RE: Monument Ridge – Retail Paint Store Final PUD Plan

Your Final PUD Plan for Monument Ridge – Retail Paint Store has been reviewed by outside agencies and Town Staff. Comments and necessary revisions have been compiled and are provided below. Some items are summarized in the interest of being concise and clear. Names and contact information are provided should you need to discuss any of the comments with the specific reviewer. Town comments are provided at the end of the letter; duplicate comments have been removed for your convenience. There may be additional comments/revisions as a result of your response to this first round of comments. We are happy to discuss any of these items, if necessary.

1 LANDSCAPE PLAN

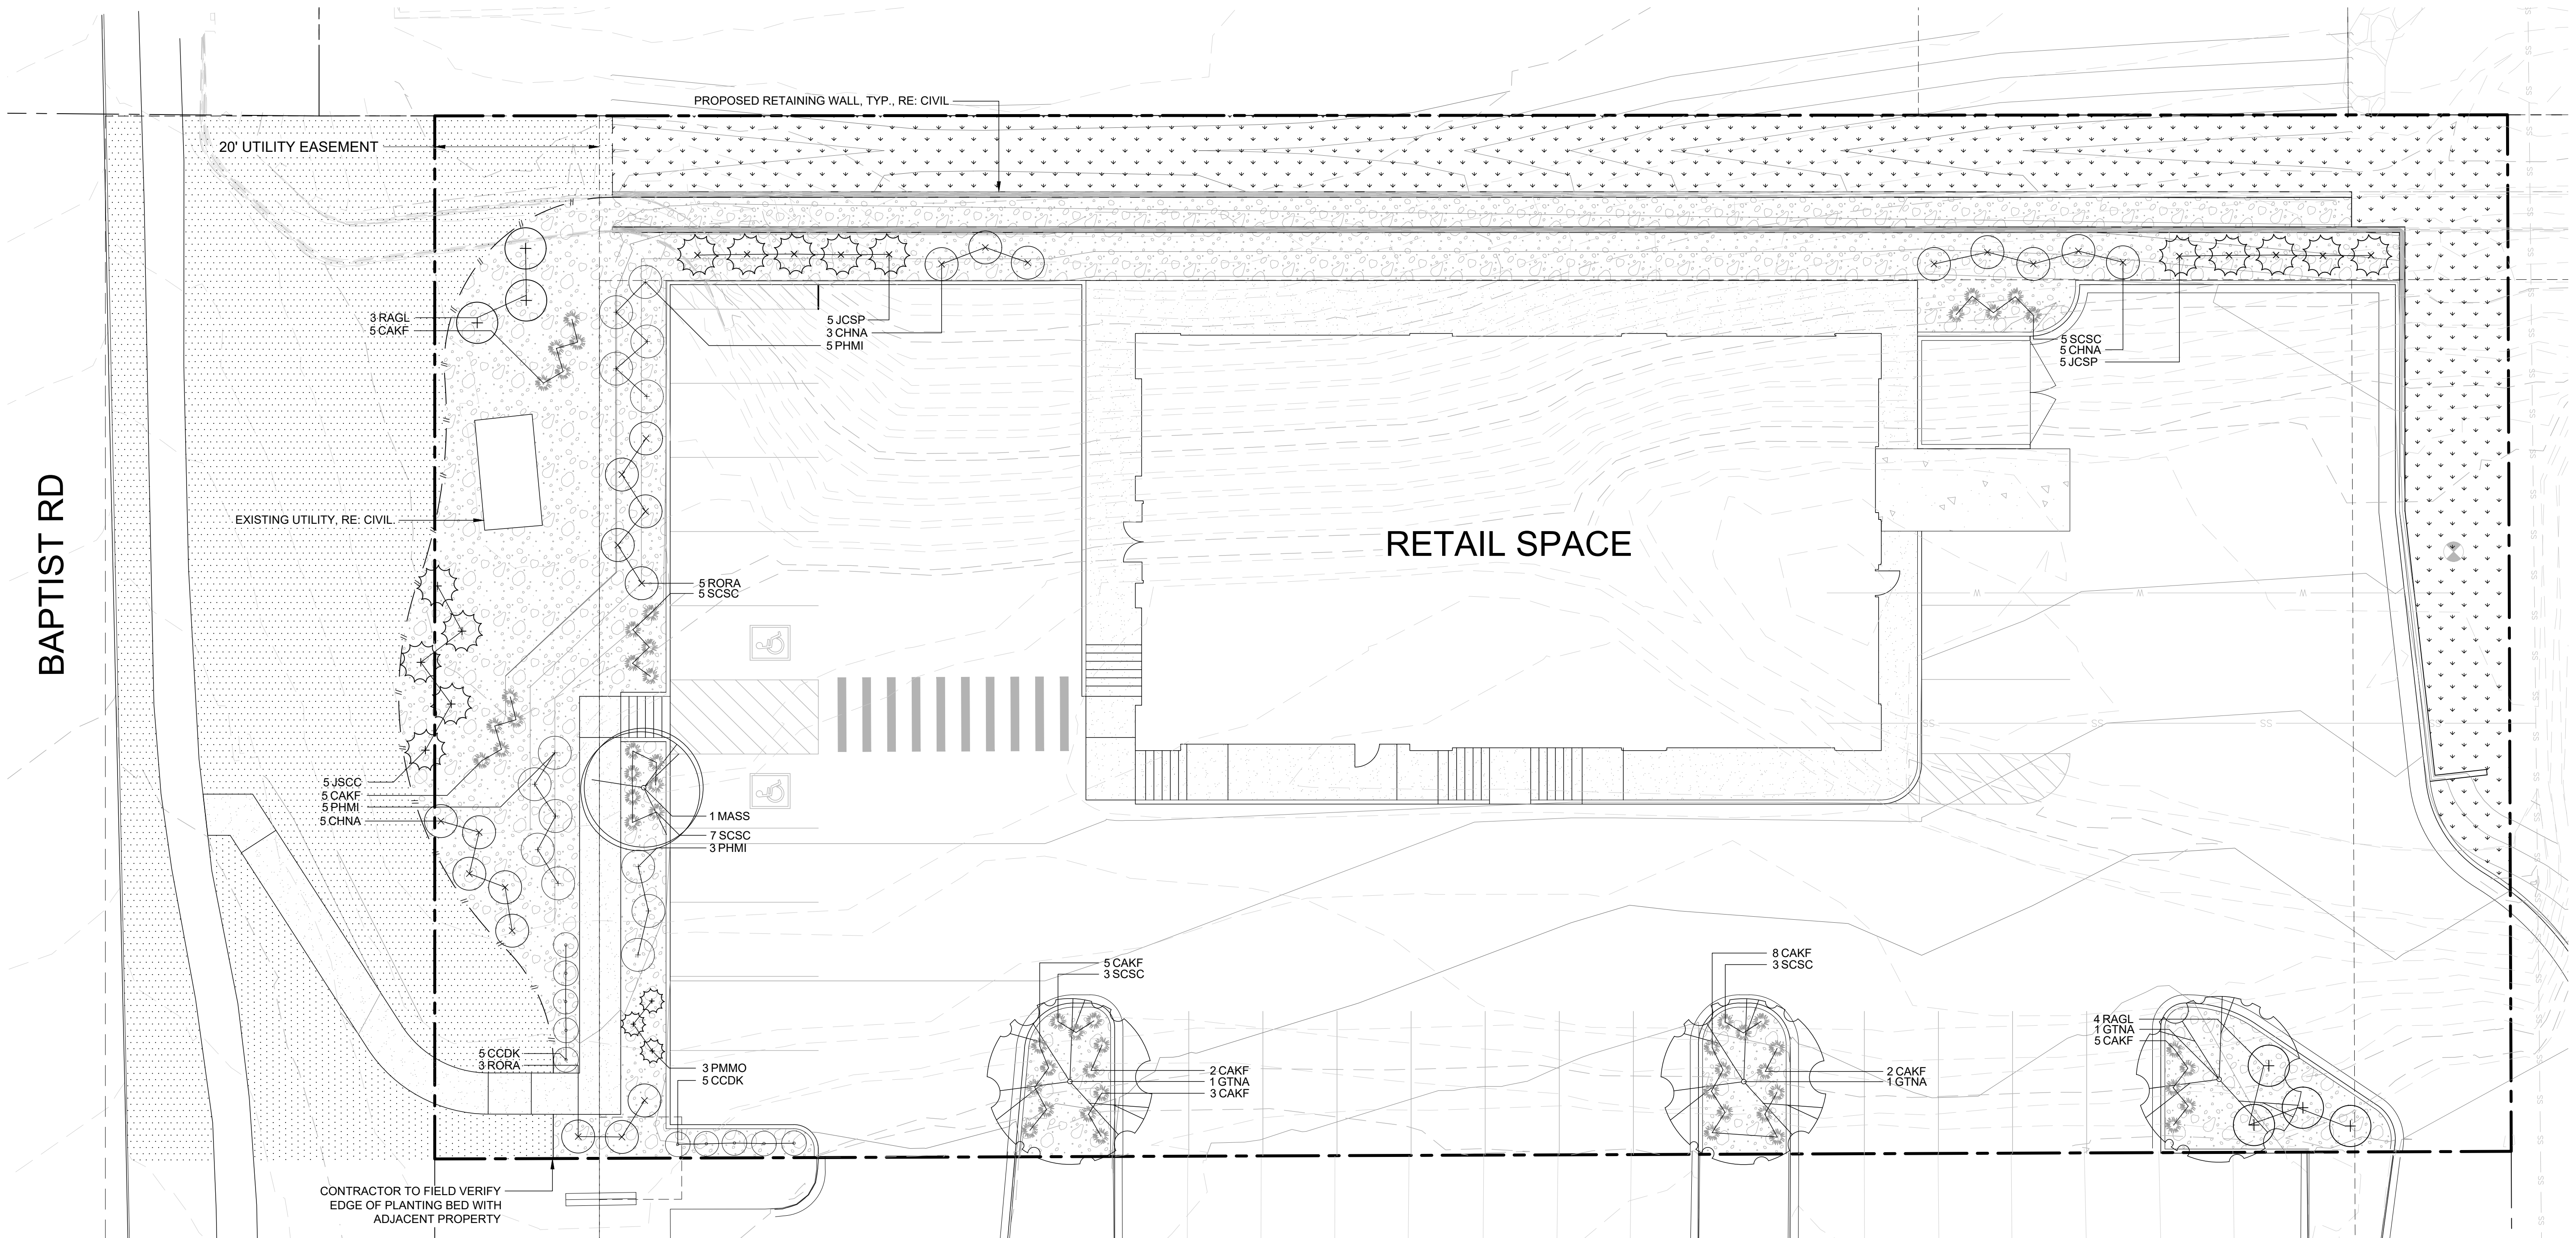
- 1. Has the proposed parking island ground cover been coordinated with Autozone's half of the islands?
Valerian Response: Proposed parking island landscaping has been coordinated with Autozone's landscape plans.
- 2. There appear to be 2 sets of existing contours on the sheet.
Valerian Response: Redundant contours removed.
- 3. Is the proposed lighting in conflict with the proposed trees (or root systems)?
Valerian Response: Proposed light does not conflict with proposed trees and their root systems.

3. Update the landscape plan by moving the landscape edger and the evergreen shrubs out of the ROW and inside the lot.

Valerian Response: Edger and shrubs removed from ROW.

1 PHOTOMETRIC PLAN
scale: 1"=20'-0"

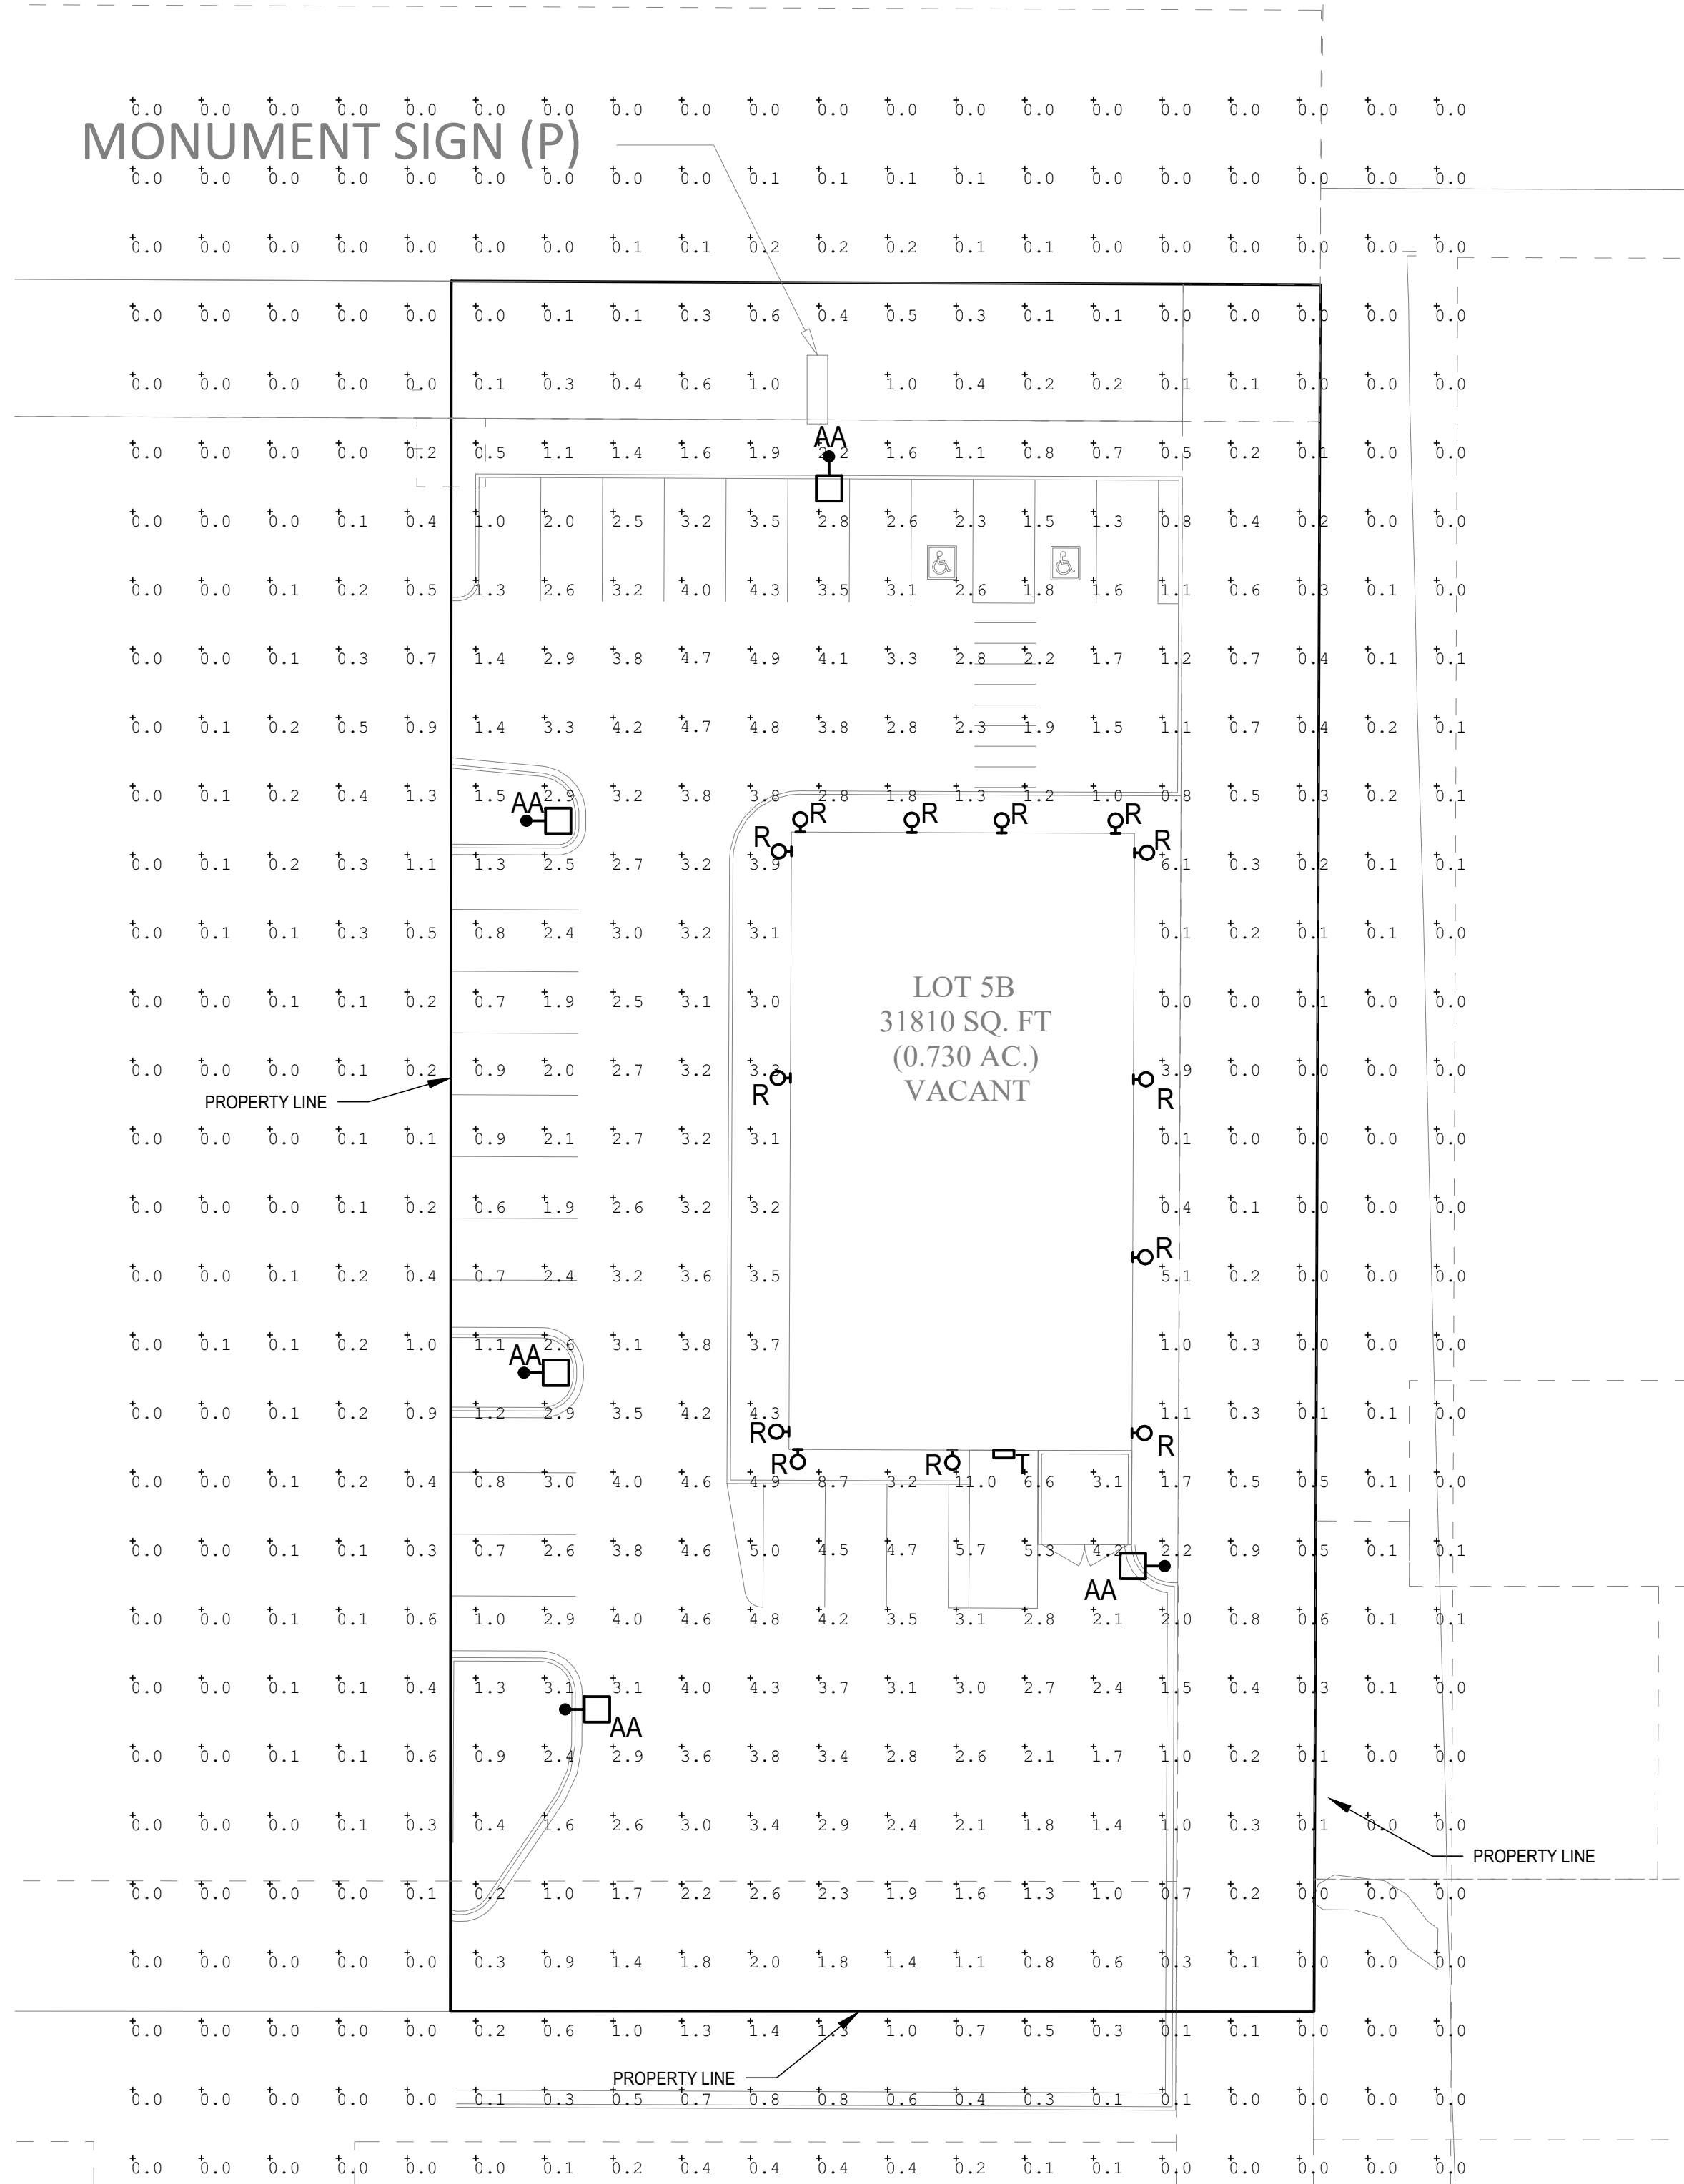
- 1. There appear to be parking light poles on the Autozone halves of the interior parking islands. Have they been considered in this lighting plan?
EES Response: These lights have been removed.
- 2. Similar comment as on the landscape plans, is the proposed lighting in conflict with the trees (or root systems)?
Valerian Response: Proposed light does not conflict with proposed trees and their root systems.

3 FLOOR PLAN
1/8" = 1'-0"

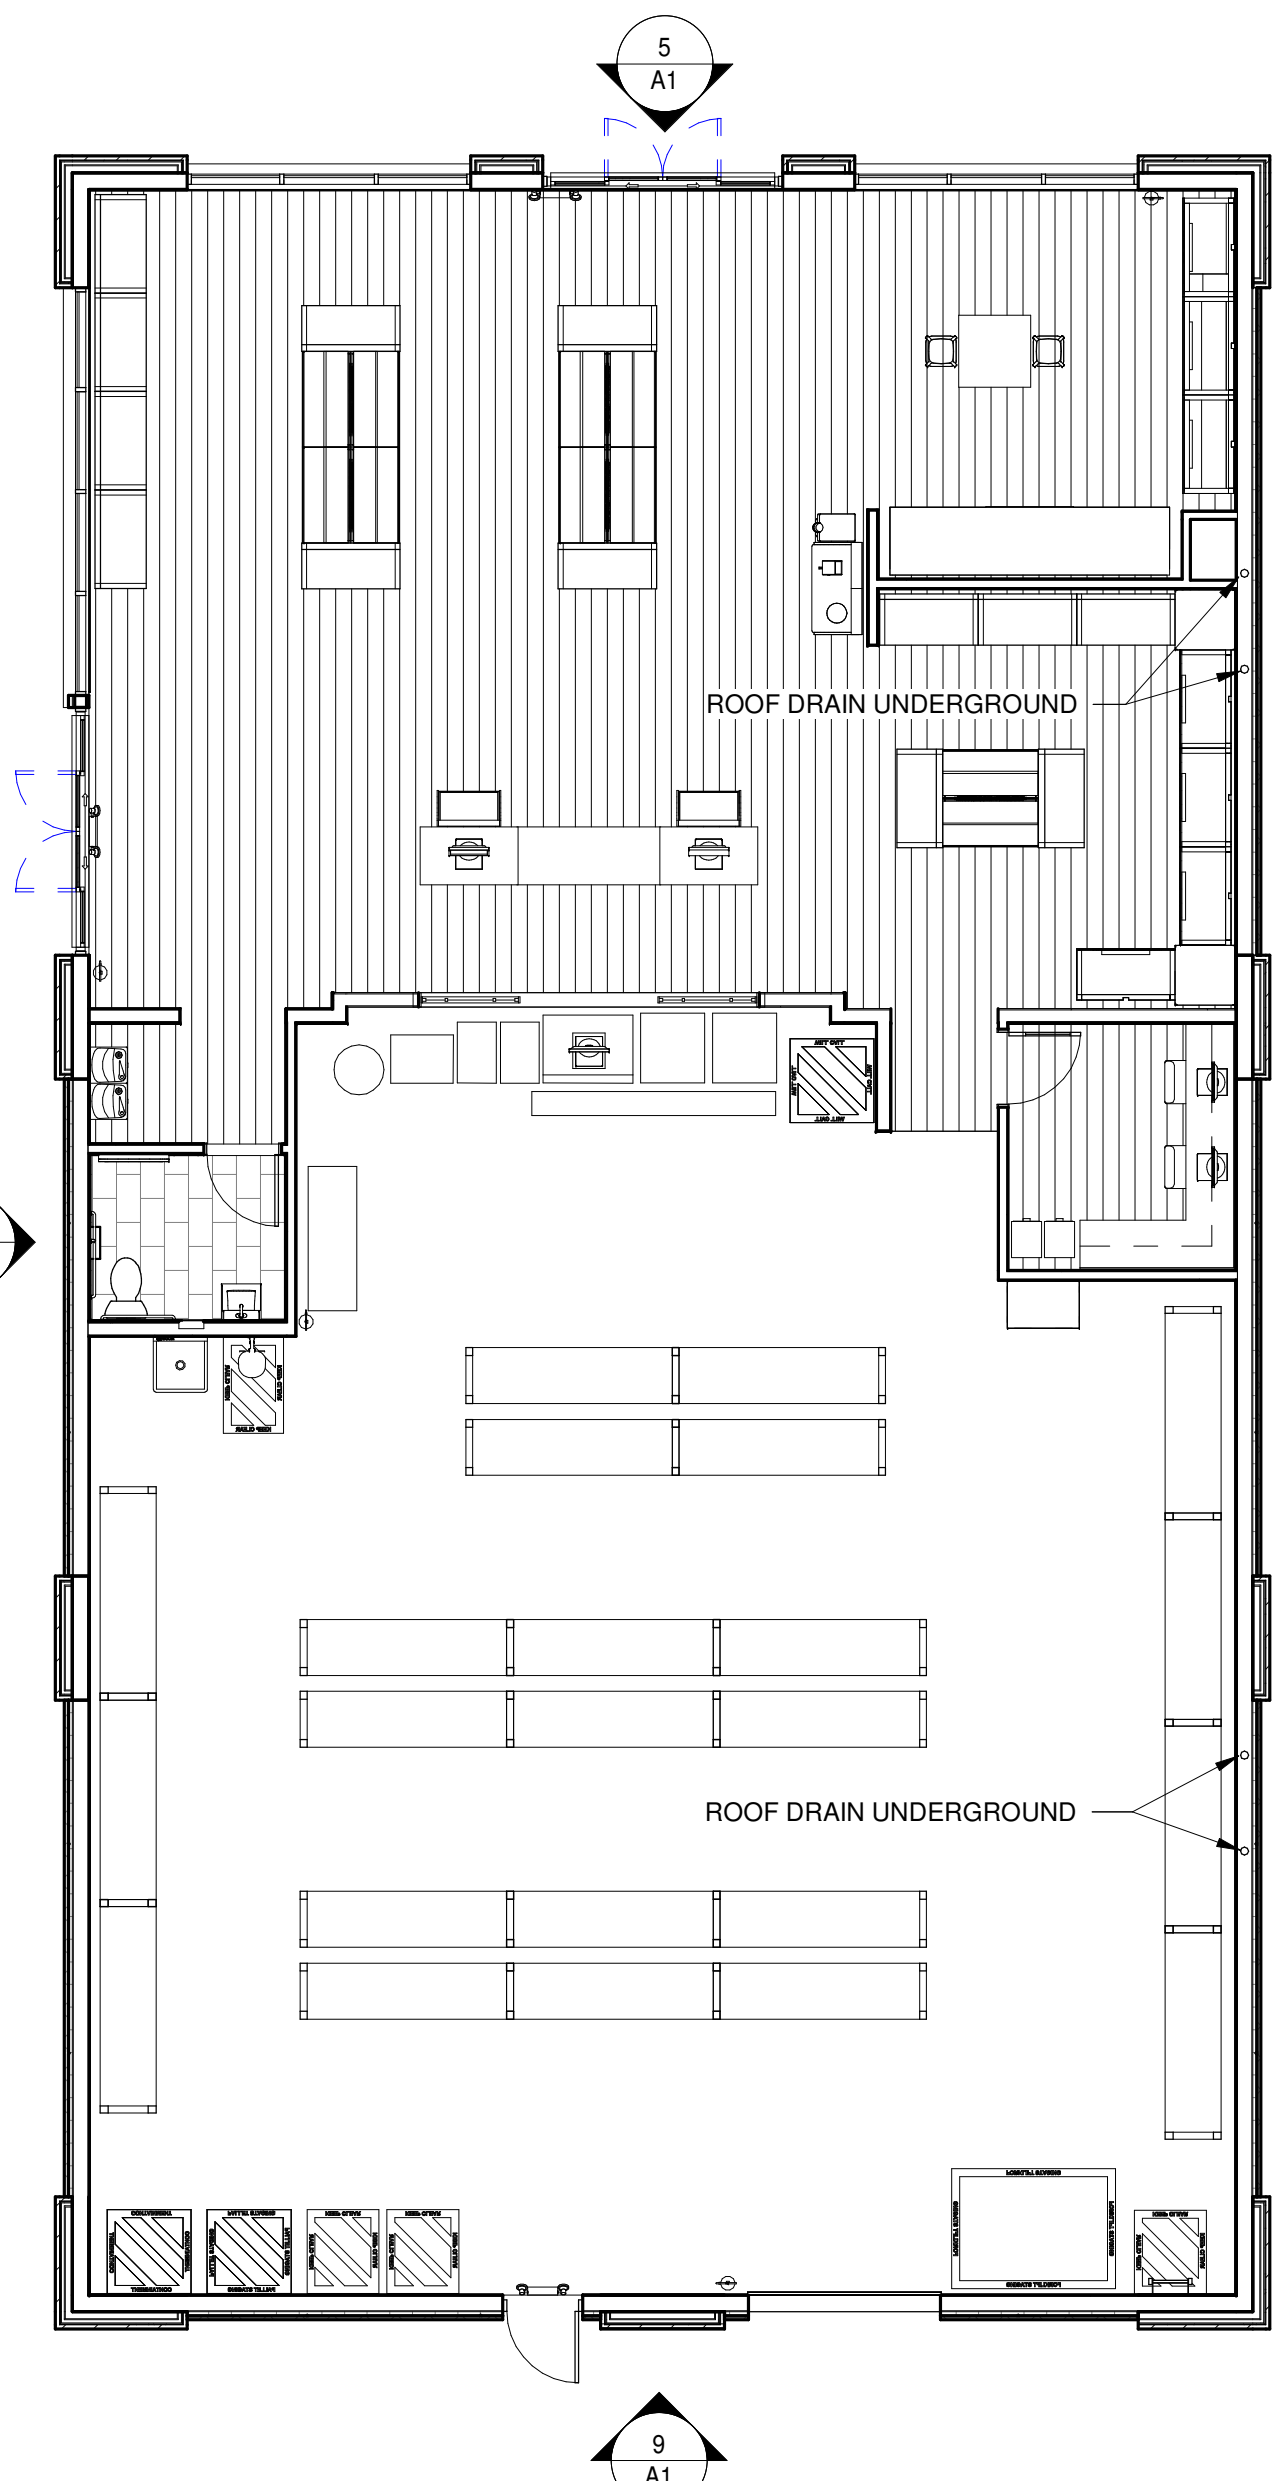
- 1. Refer to the Final PUD checklist for additional Floor Plan requirements.
Lingle Response: Acknowledged.
